M/80/25/L

Ancton Manor Ancton Lane Middleton-on-sea PO22 6NJ

Listed building consent to replace 3 No wooden storm type windows with PVCu mullions and casement openings on south elevation (rear) with Georgian lights with casement openings & fanlights.

PROPOSED SECTIONS
FOR ANCTON MANOR

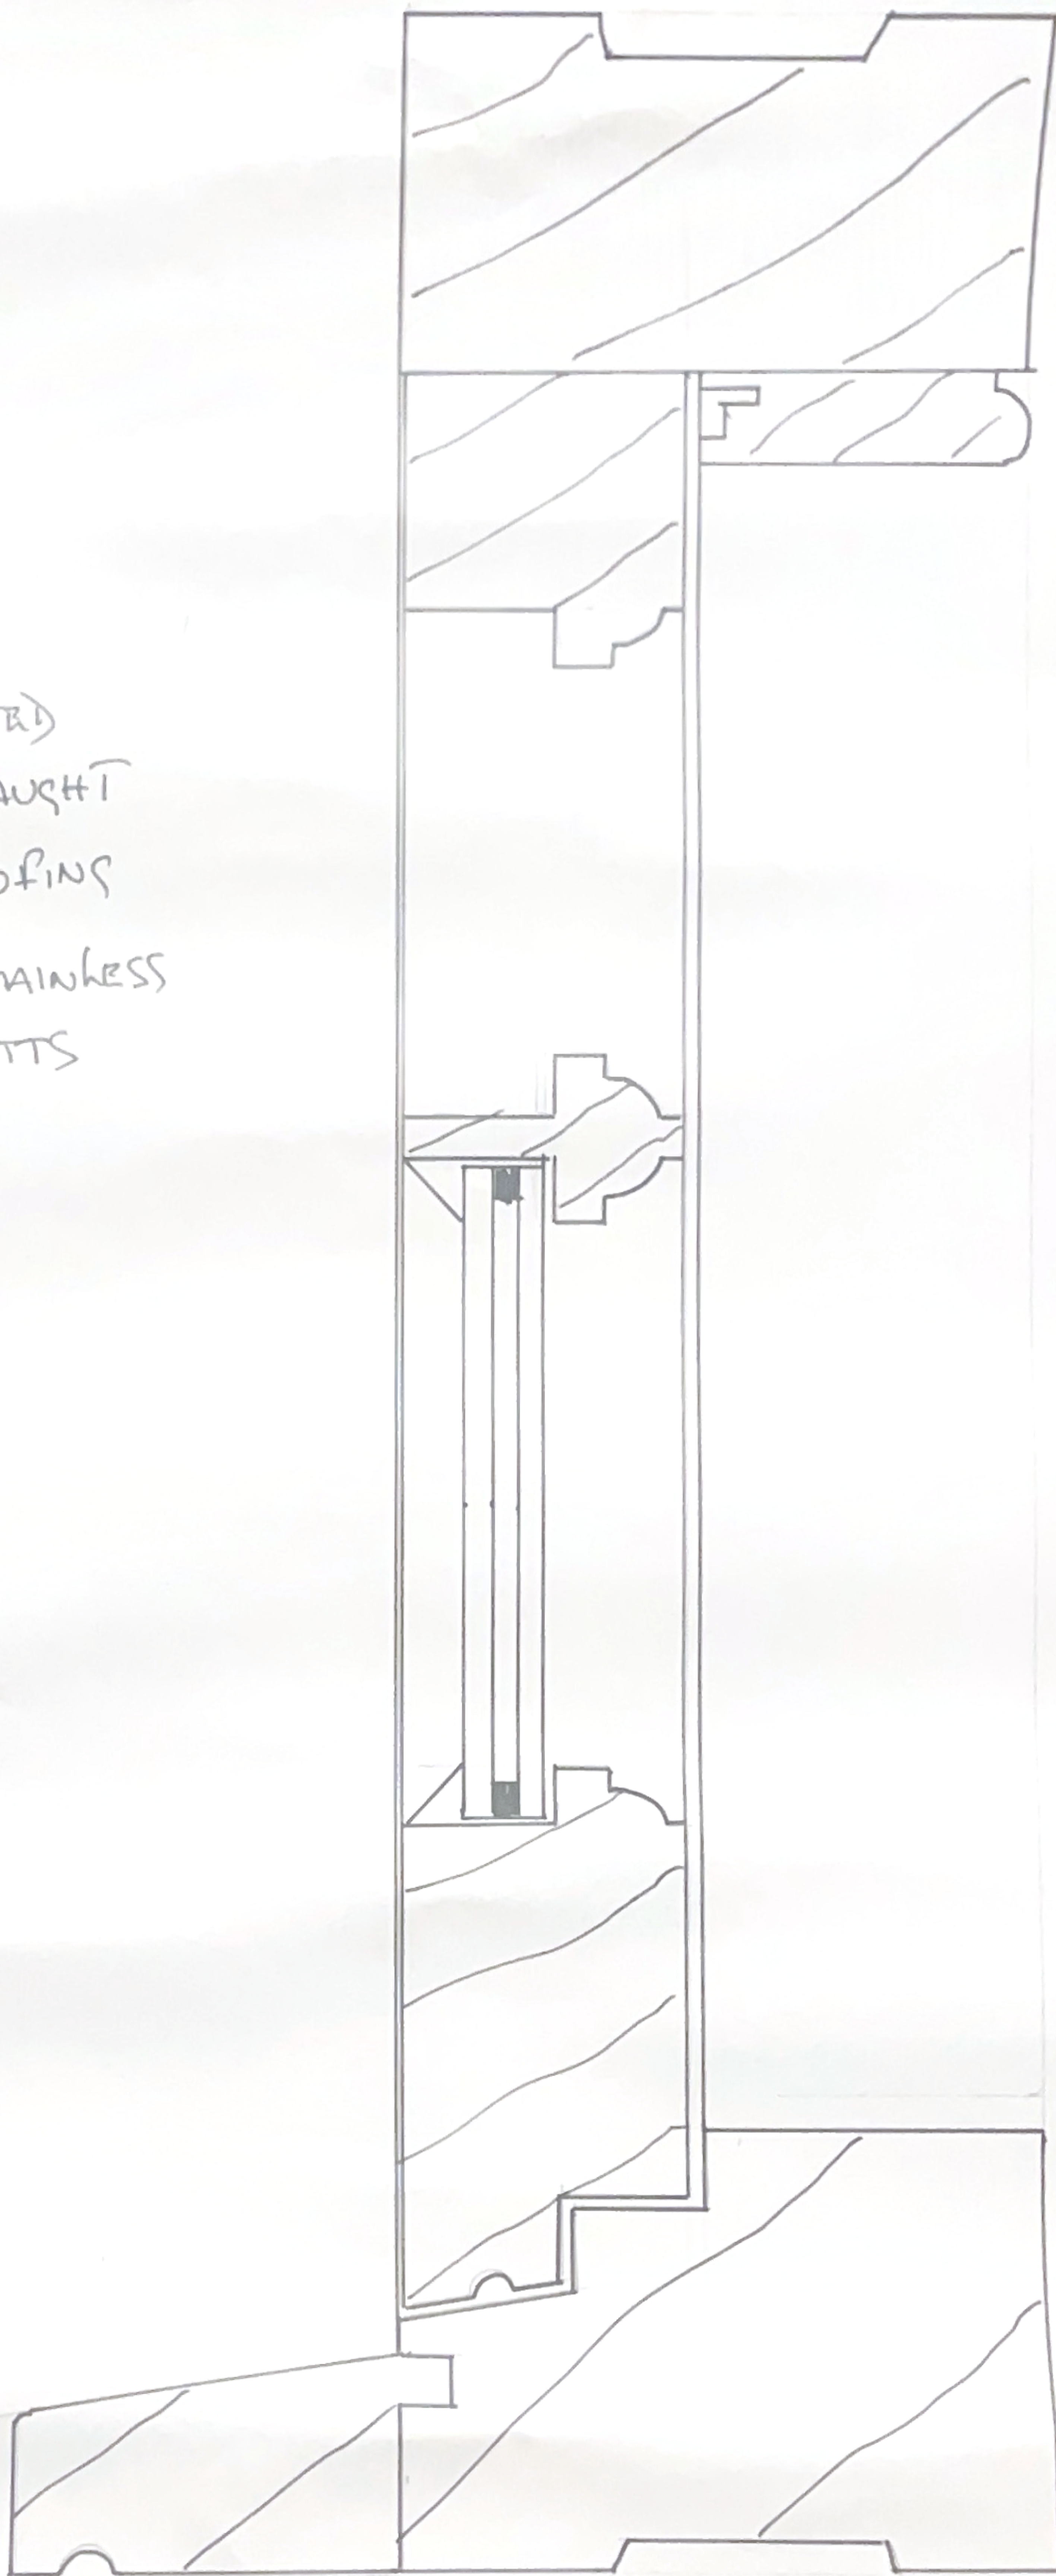
The proposed design appears to incorporate integral glazing bars, which are typically structural in historic windows. However, further detail on their dimensions would be helpful to ensure they are appropriate and do not compromise the authenticity of the design.

Unfortunately, only a section drawing has been provided, rather than a full front elevation. As a result, it is unclear whether the proposed windows would match the existing in terms of overall appearance and detailing. It is also not evident whether if any or all of the windows would incorporate fanlights, or if this feature would be limited to a single unit as currently present. Clarification on these points would be appreciated to ensure the proposals are consistent with the building's architectural character.

Further information is required in order to be able to understand the design of the window before a conclusion regarding the impact of the proposal can be reached. Please can this information be provided.
